Subject: FW: LU/370/21/PL - Amended Plans for Phase 3 at Hampton Park

Please find attached the amended plans for **LU/370/21/PL** for Phase 3 at Hampton Park.

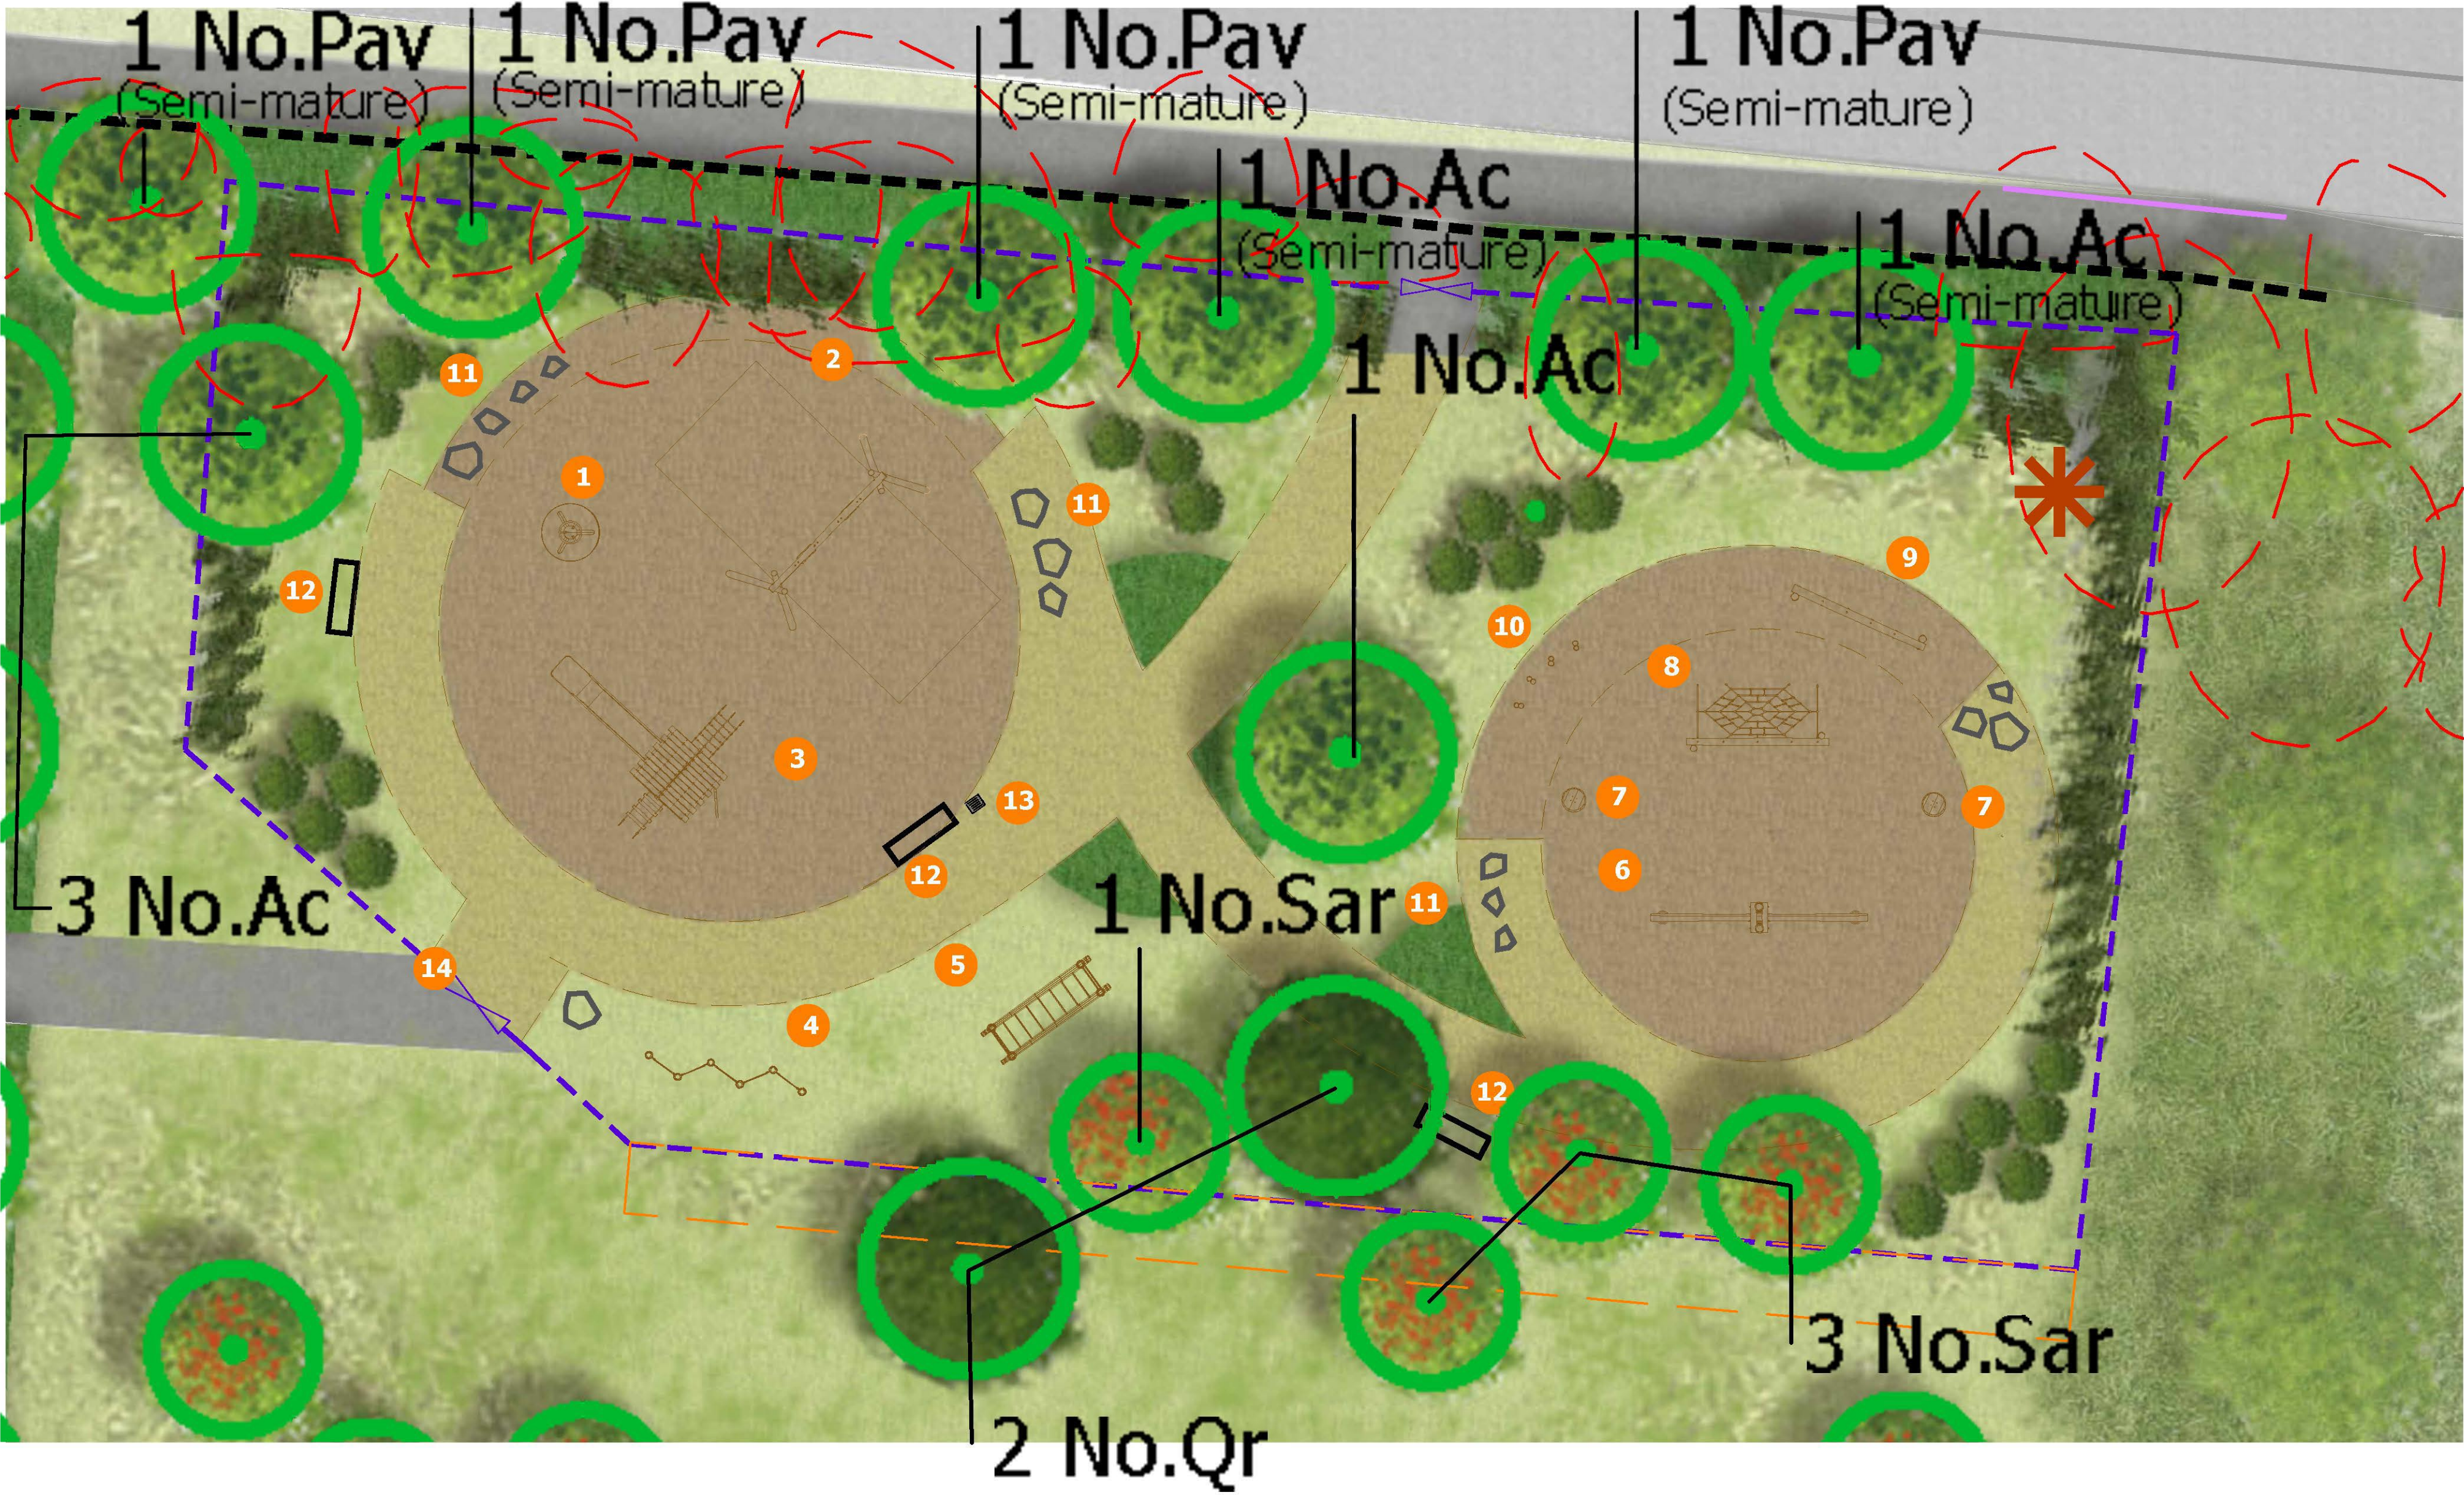
Further to receipt of amended plans, I can confirm that the minor amends re annotation and tree species change from Oak to Whitebeam are acceptable and I would recommend no landscape objection to the proposals.
